Rezoning Transportation Analysis

Petition Number: 2023-023

From: Jake Carpenter, PE
Jacob.carpenter@charlottenc.gov
980-221-5675

Date	Description
7-26-23	First Review (IW)
11-27-23	Second Review (DR)

TECHNICAL DATA SHEET

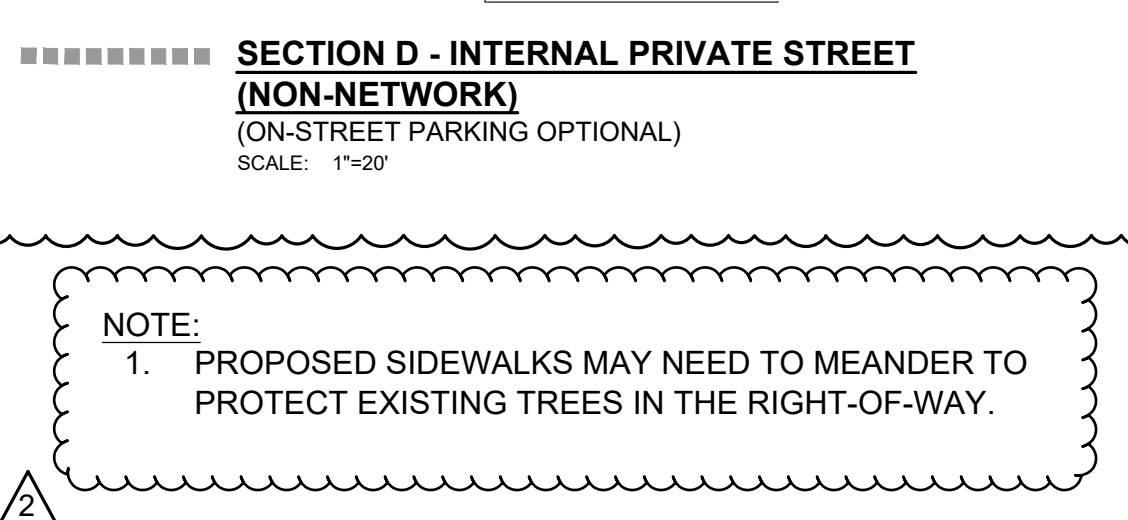
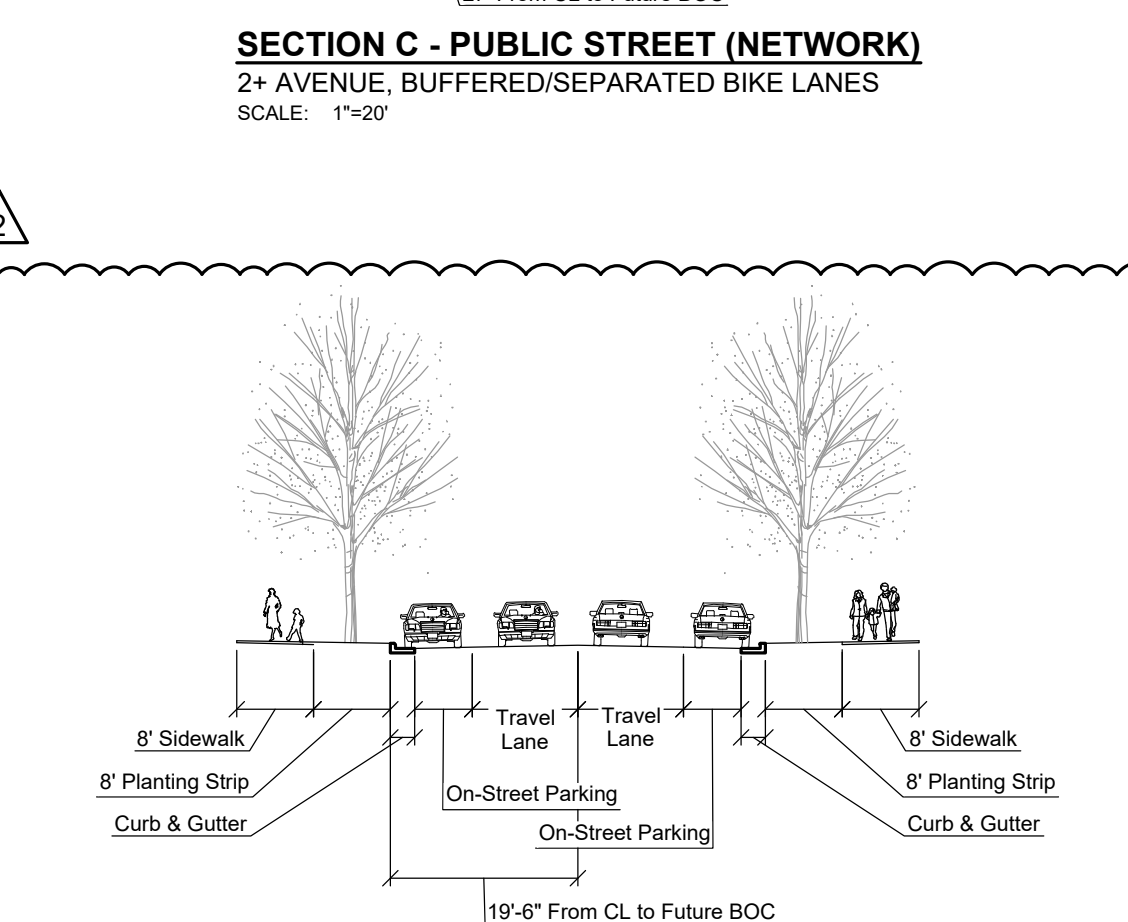
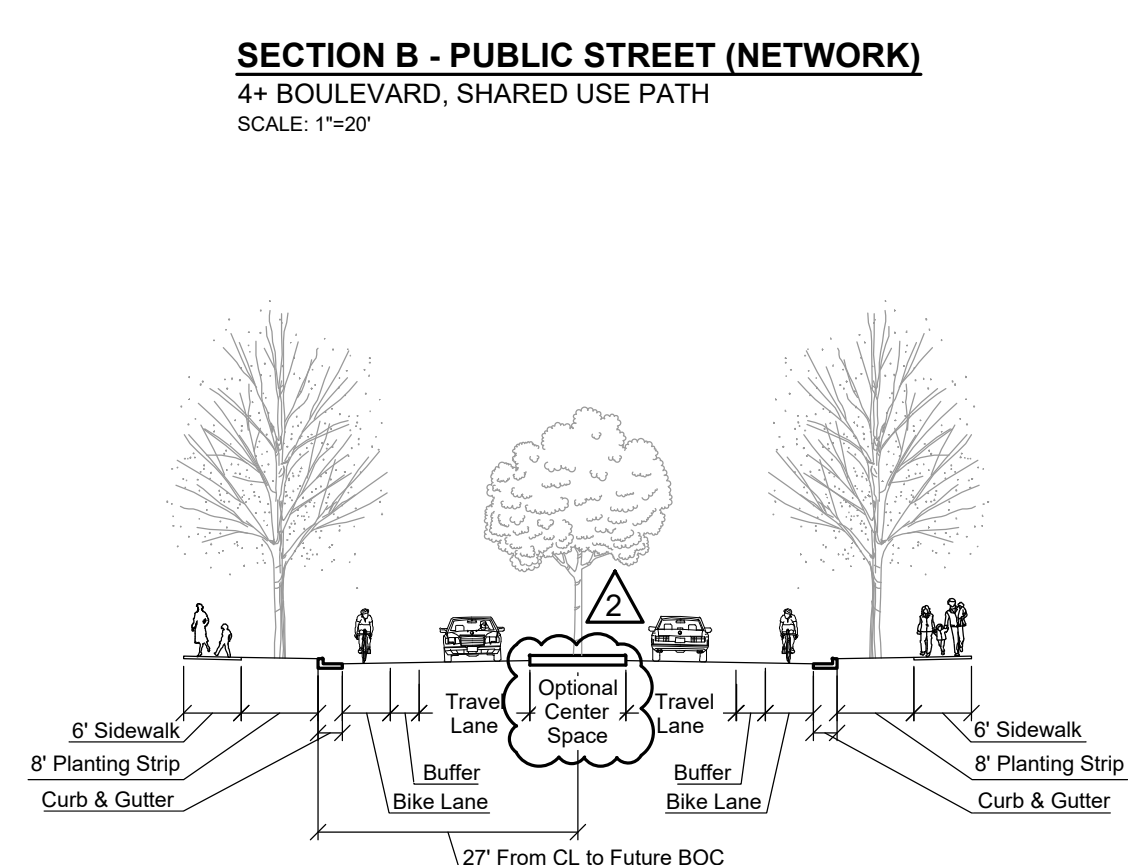
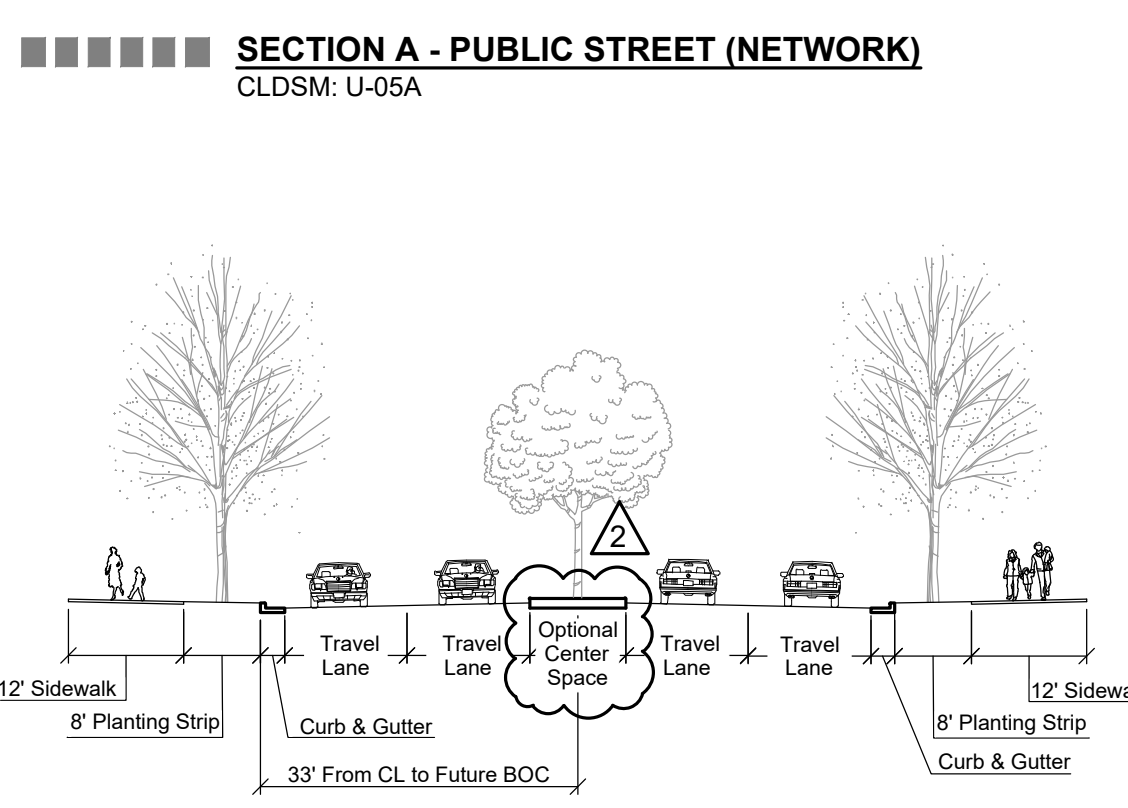
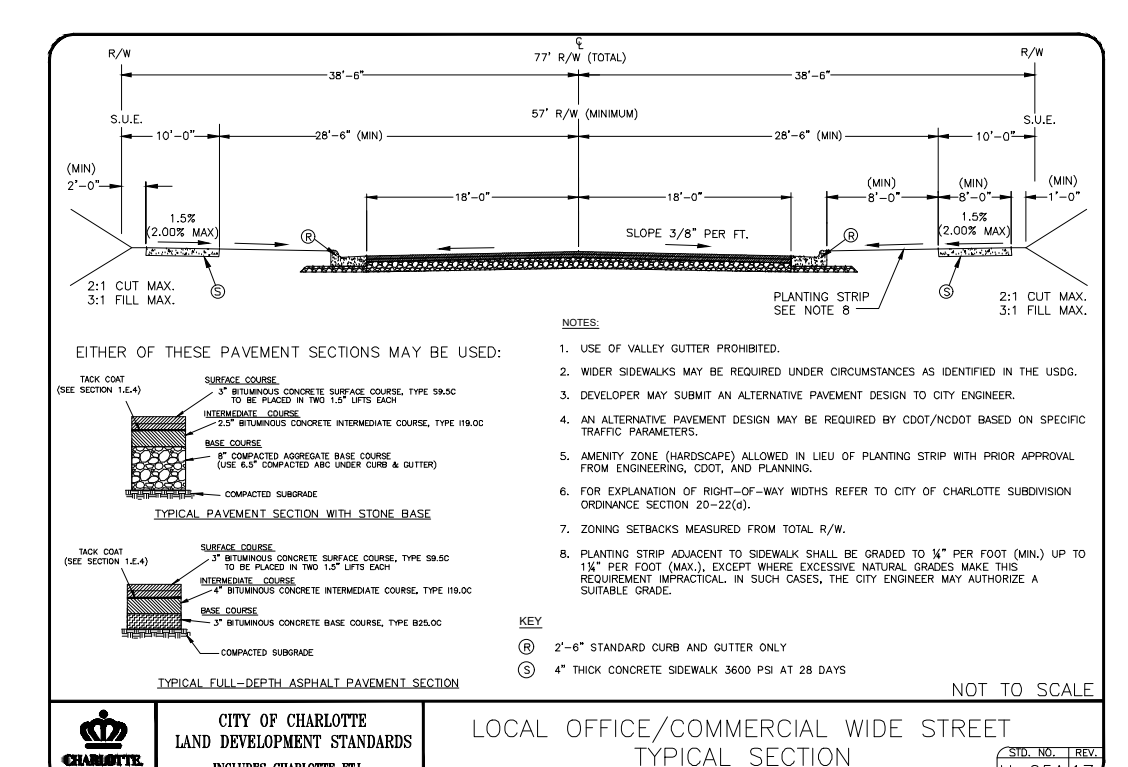
7. The proposed dwelling units exceeds 12 per acre. Per Chapter 20 Subdivision ordinance, revise site plan and conditional note(s) to commit to construct an 8-foot planting strip, and 8-foot sidewalk along Old Providence Road. The wider sidewalk also meets the Charlotte WALKS Policy.

New Comment 11.27.23: Section C public street network sidewalk width does not match the conditional note. Revise Section C to have an 8' sidewalk like the conditional notes for the Old Providence Road section.
